WEST SUSSEX COUNTY COUNCIL CONSULTATION

TO:	Arun District Council FAO: Simon Davis
FROM:	WSCC - Highways Authority
DATE:	4 December 2019
LOCATION:	Rear of Inglenook Hotel 253-255 Pagham Road Bognor Regis PO21 3QB
SUBJECT:	P/58/19/PL Erection of 9 No. dwellings with associated access, parking, cycle & refuse storage & landscape design. This application is a Departure from the Development Plan & may affect the setting of a listed building. Updated location and site plans attached.
DATE OF SITE VISIT:	20th November 2019
RECOMMENDATION:	Advice
S106 CONTRIBUTION TOTAL:	n/a / £ See below for breakdown.

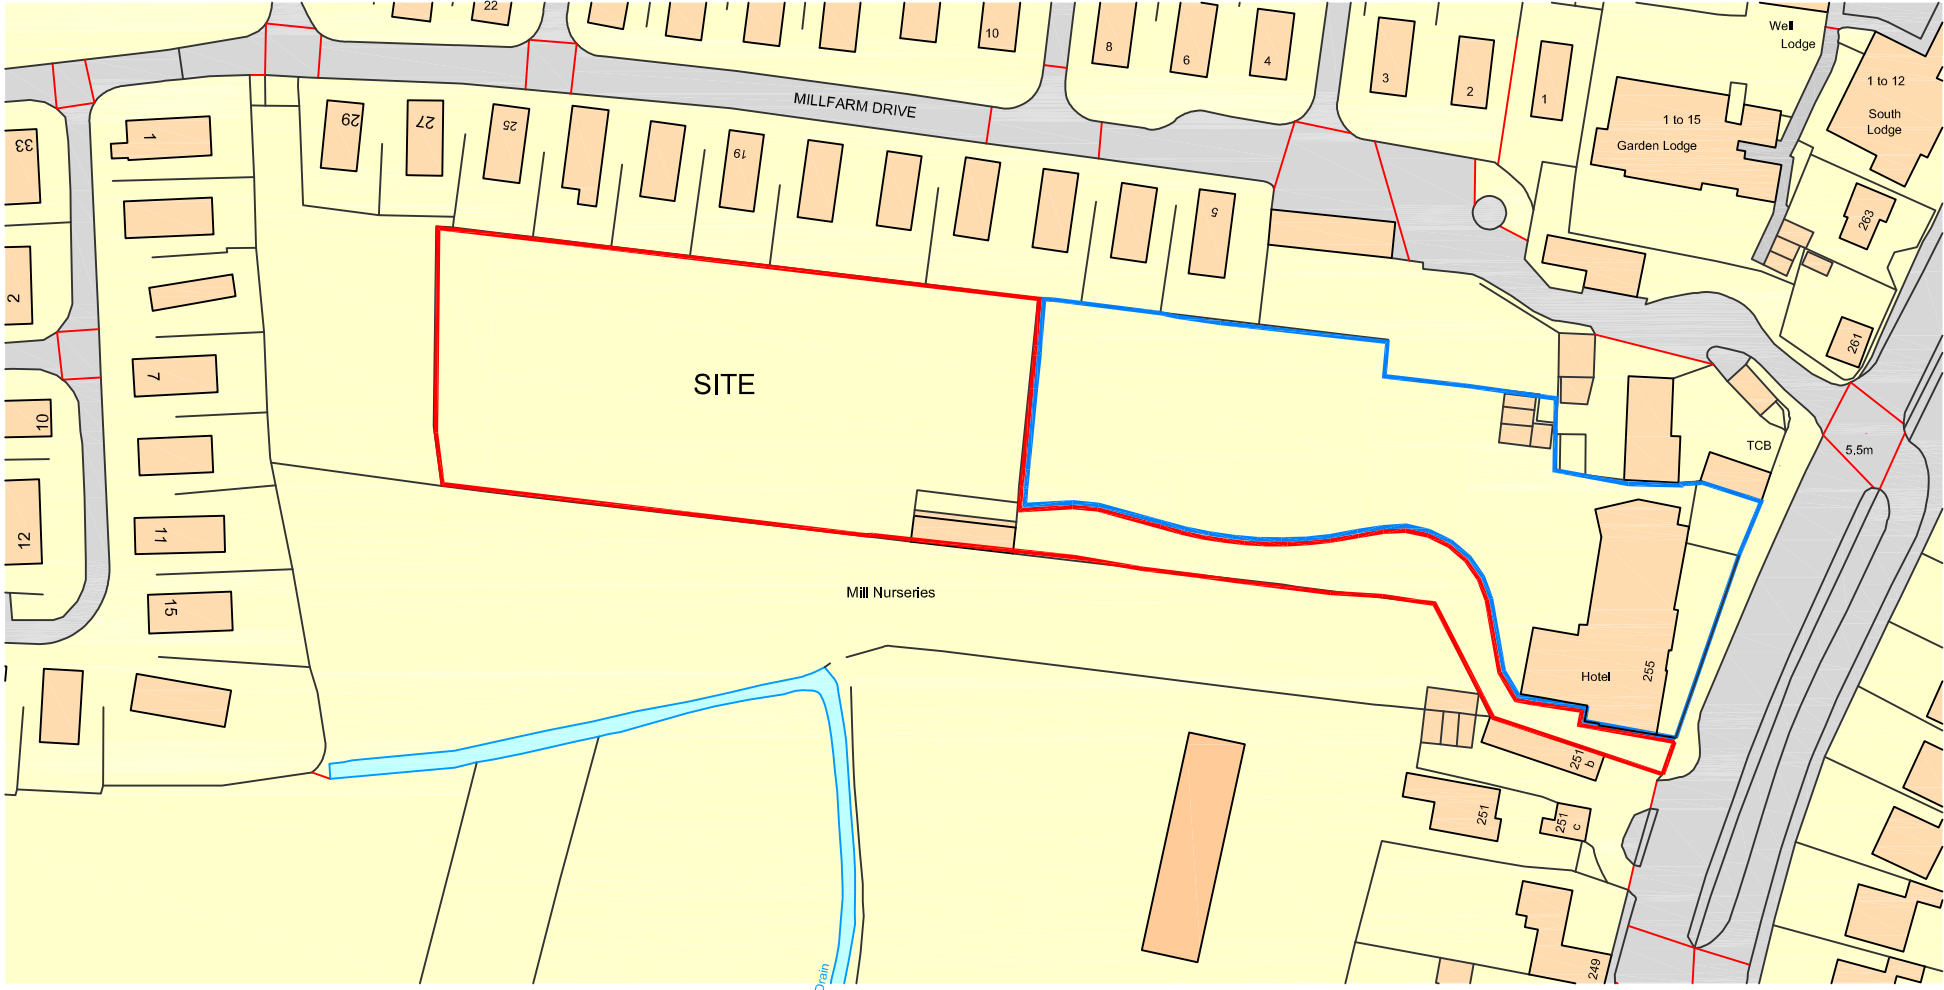
After the meeting the following areas have been modified by the applicant which have been demonstrated in drawings 01A and 13F provided through the Local Planning Authority :

- The overall red edge has been amended to include an alternative pedestrian route through the grounds of the hotel. This will be bonded gravel so will be more accessible for wheelchair users. This will be a resident only route and will be controlled by a key/pin code on a gate.

It is considered the modifications provided will result in an improvement to the overall accessibility and internal layout of the site for pedestrians. On that basis the LHA would support the modifications proposed by the applicant.

Visibility Splays and Internal Swept Path Analysis

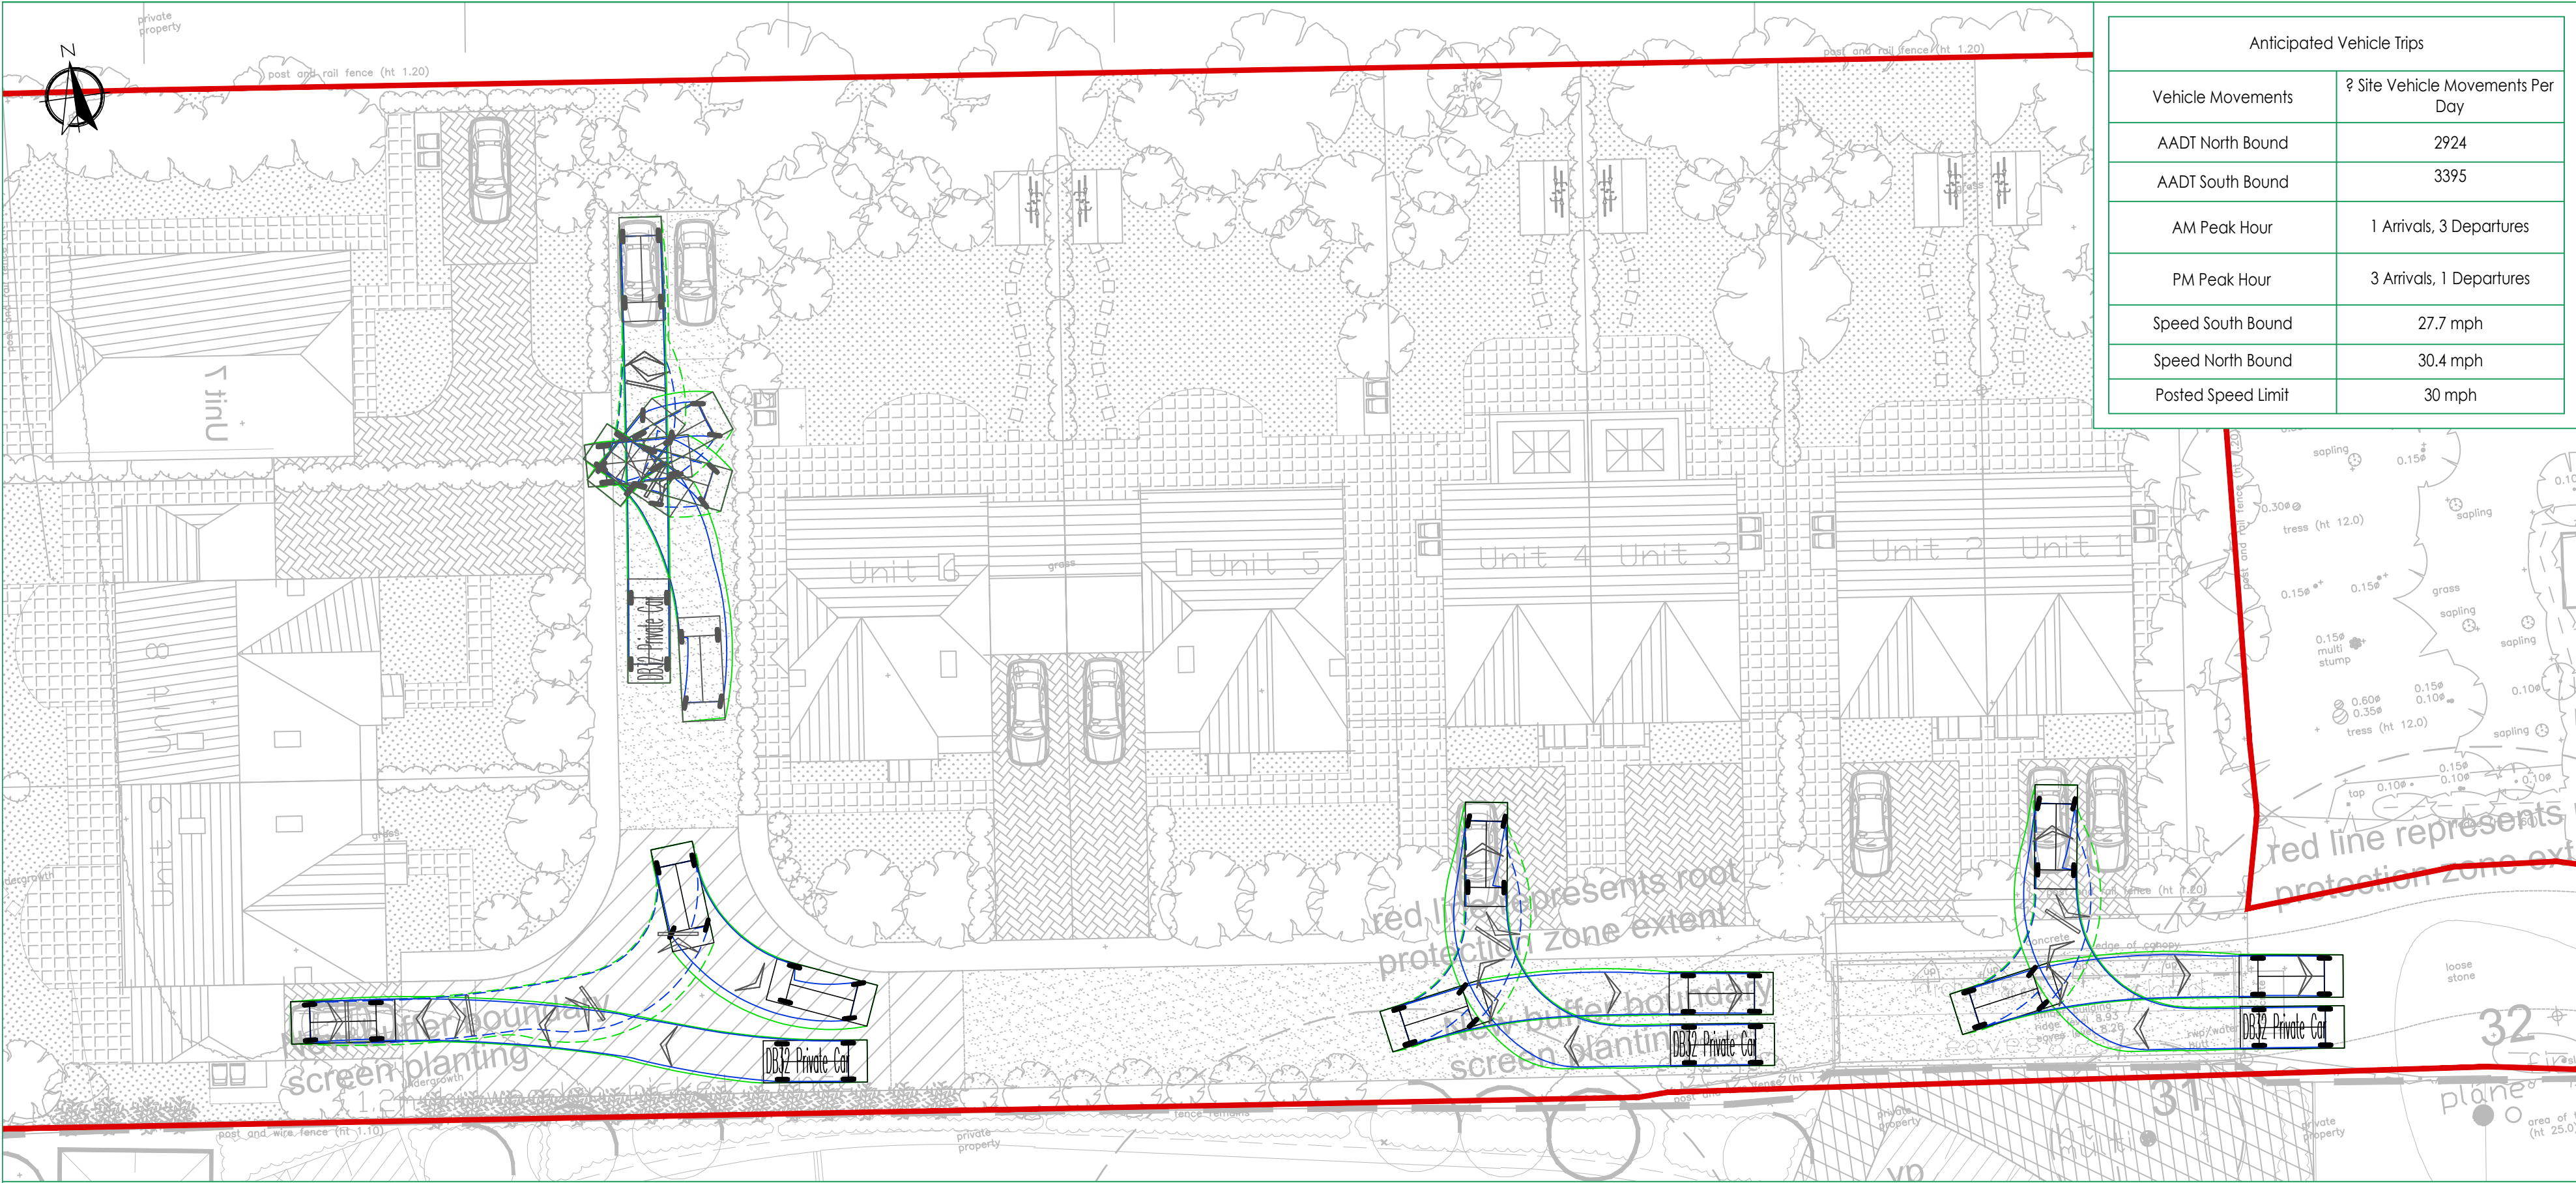
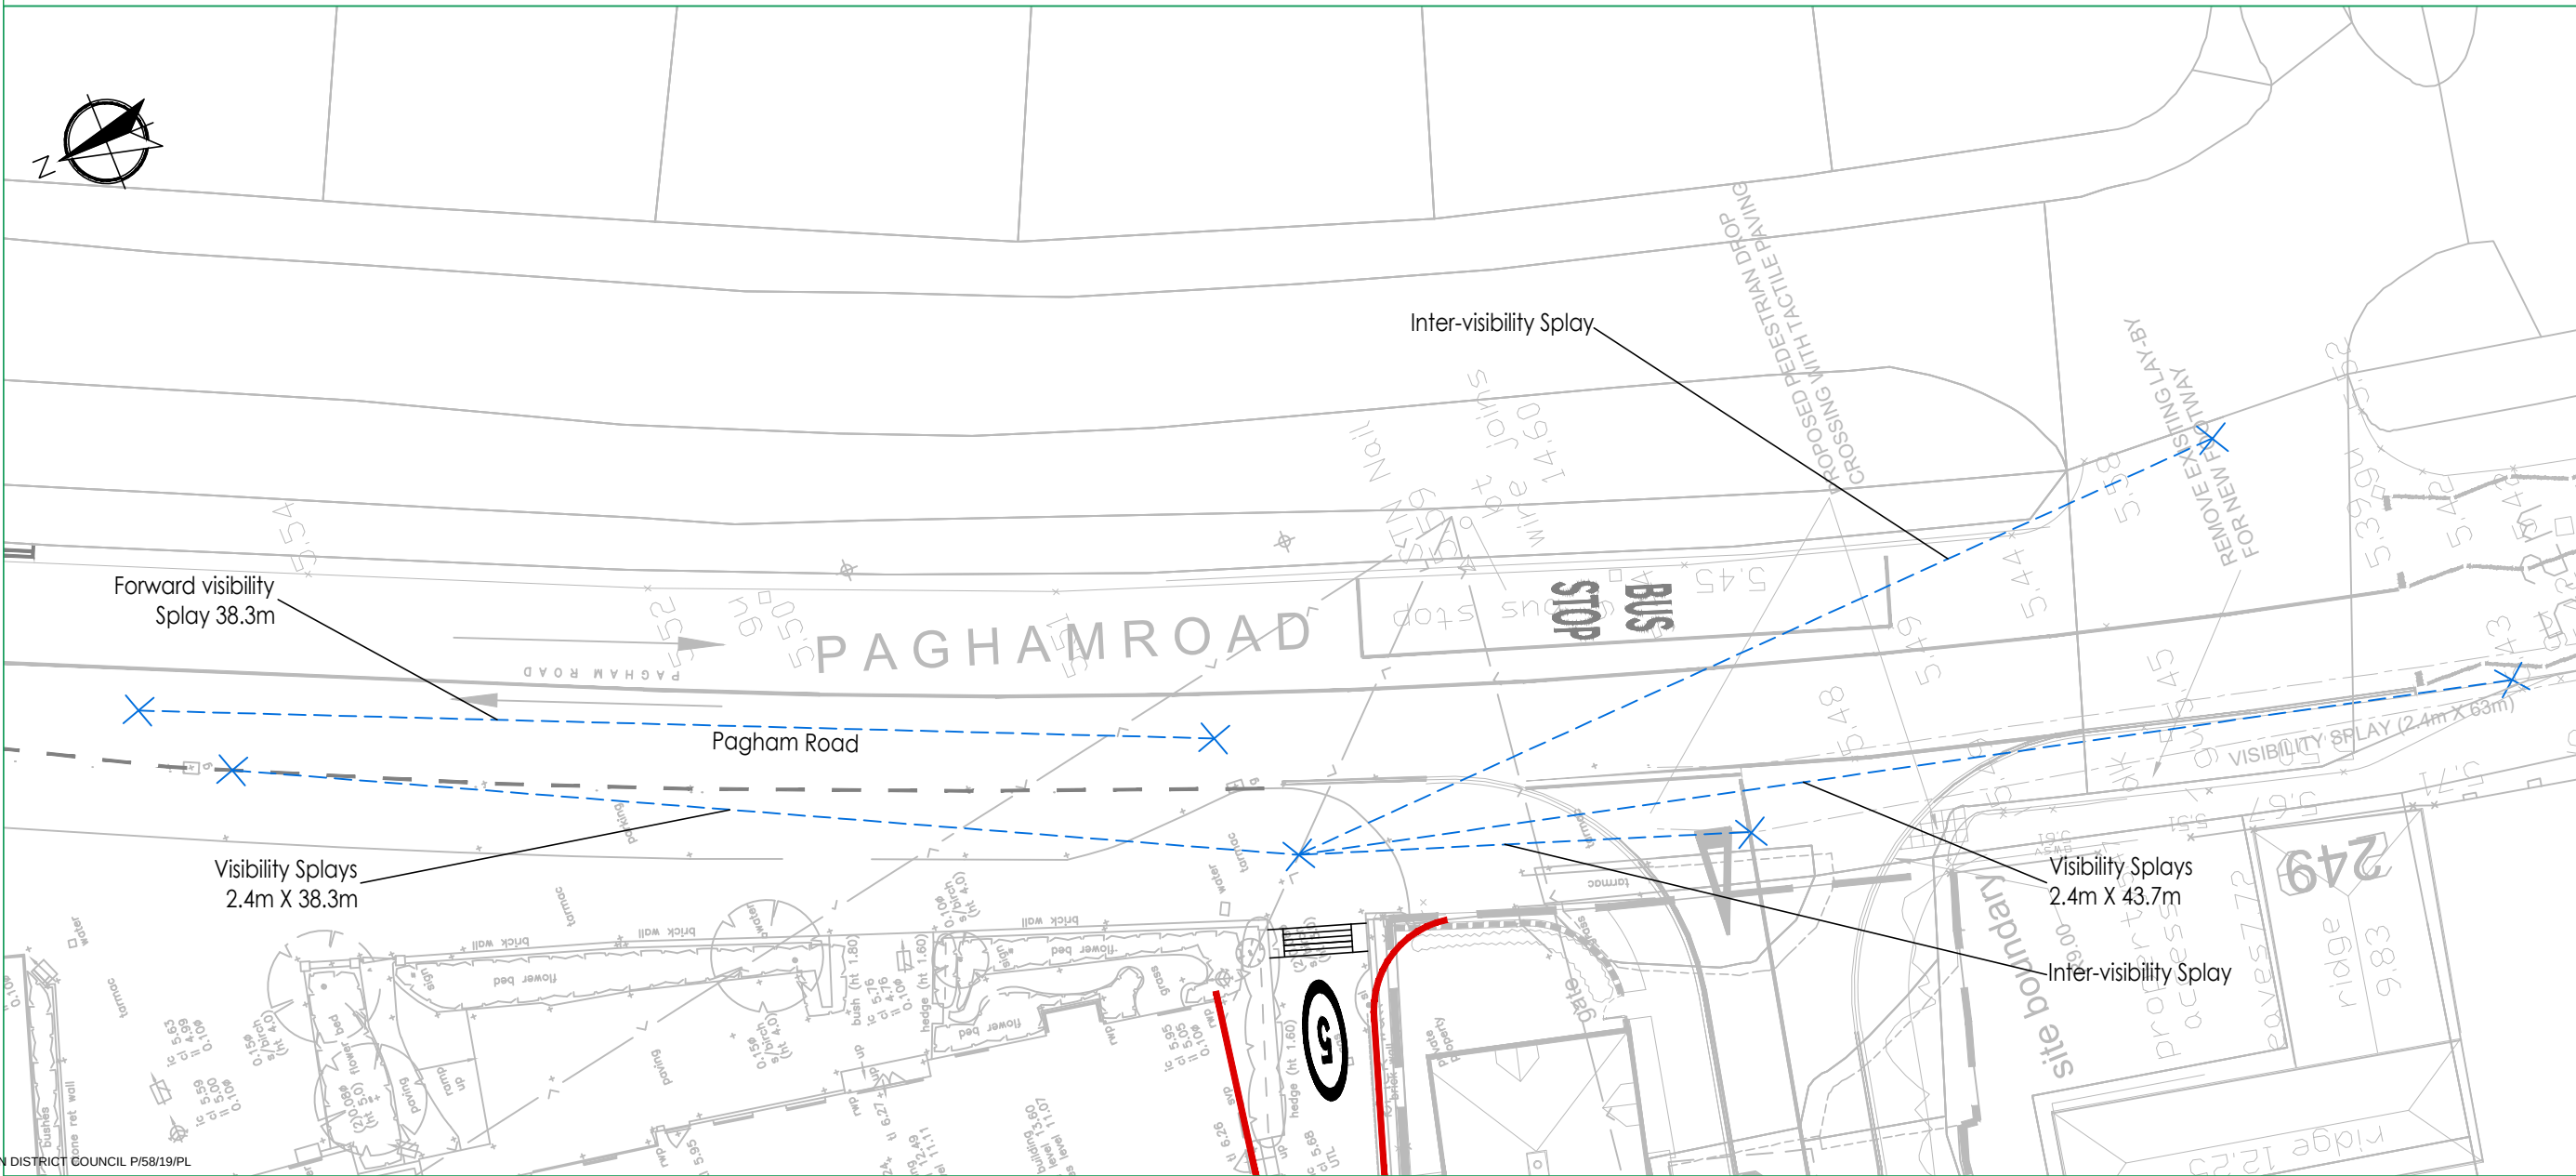
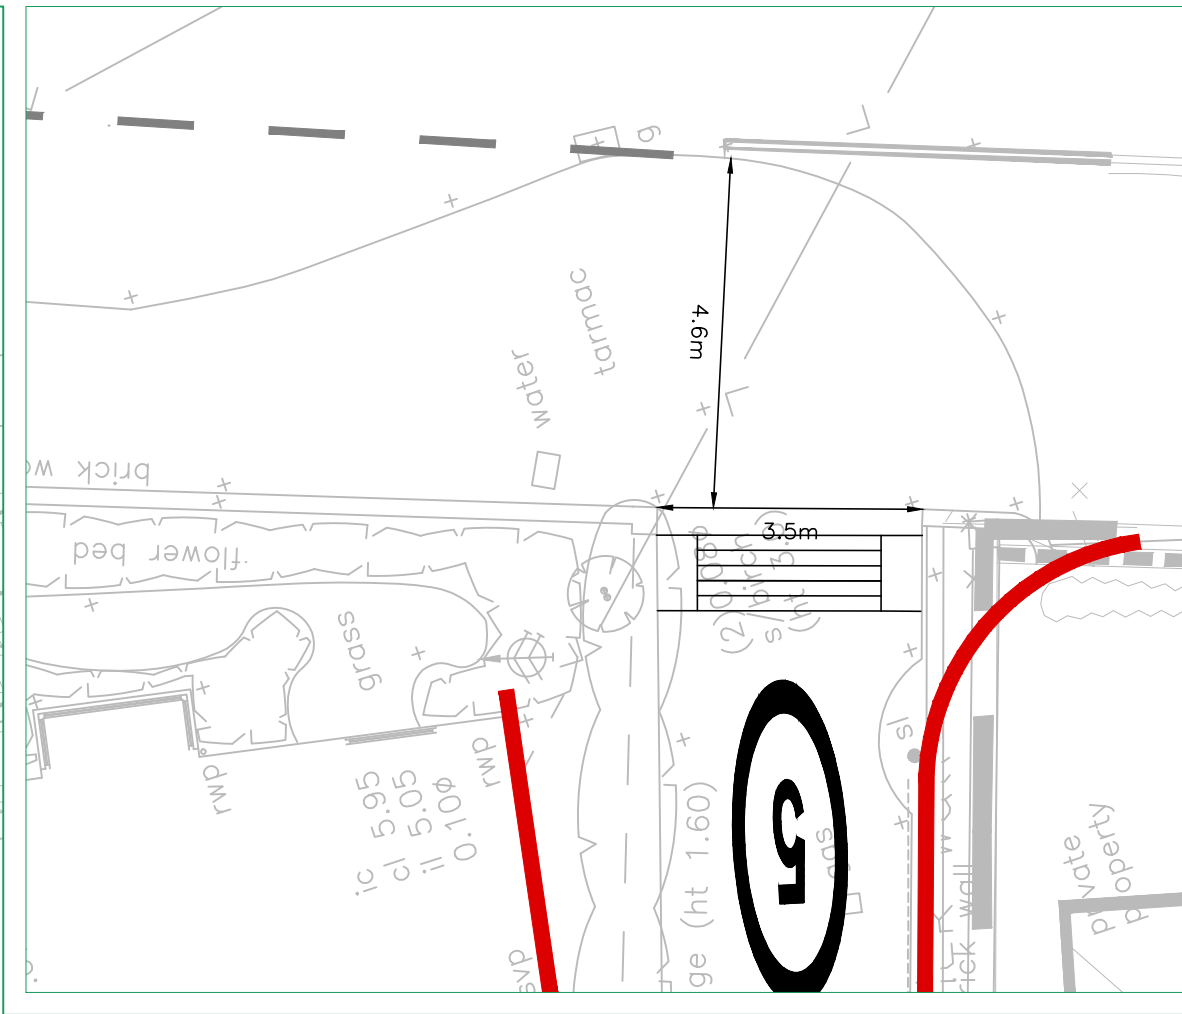
- On site it was observed that forward visibility could be improved at the section of the site near the existing car park. To improve forward visibility the applicant has confirmed they will remove 2 small conifer trees from their position adjacent to the access drive opposite the existing pub car park entrance. The LHA would concur that this should help enhance forward visibility for pedestrians and drivers.

- The applicant will now be providing a bonded gravel pavement on the shared drive to separate the pedestrian section from the road.
- Finally signage to advise vehicles entering the access from Pagham Road to expect pedestrians etc in the road will be provide within the applicants control.
